PLANNING CONSULTATION RESPONSE

Application No	2026/0254
Proposal	Corten Steel visual marker/sculpture on Trans Pennine Trail (12ft tall 2ft wide).
Address	TPT Entrance, Park Road, Worsbrough, Barnsley
Date of Consultation Reply	30/04/26
Consultee	Highways DC

Site Plan: Showing position of the concrete base

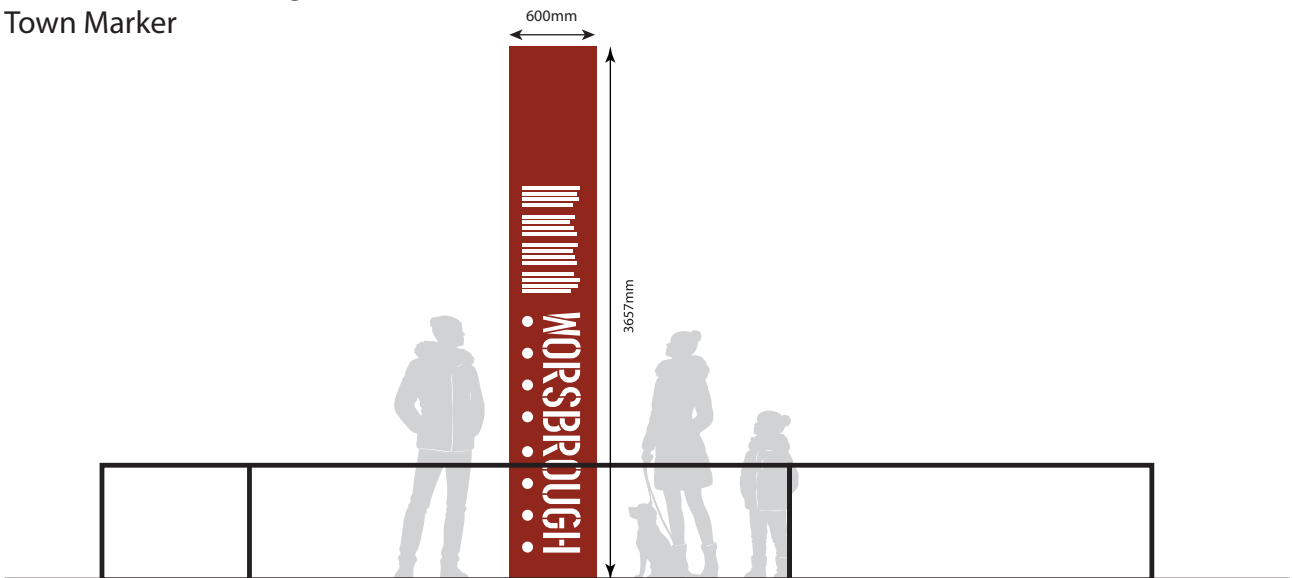
The proposed location of the site is away from the crossing signal heads and does not have an impact on the visibility of drivers on Park Road nor the intervisibility between pedestrians using the TPT and drivers.

However, whilst HDC officers have no wish to raise objection to the principle of the scheme, given the size and location of the sculpture adjacent to the highway, it is asked that a Stage 1 and 2 Road Safety Audit is carried out and submitted before final comments are provided by Highways Development Control.
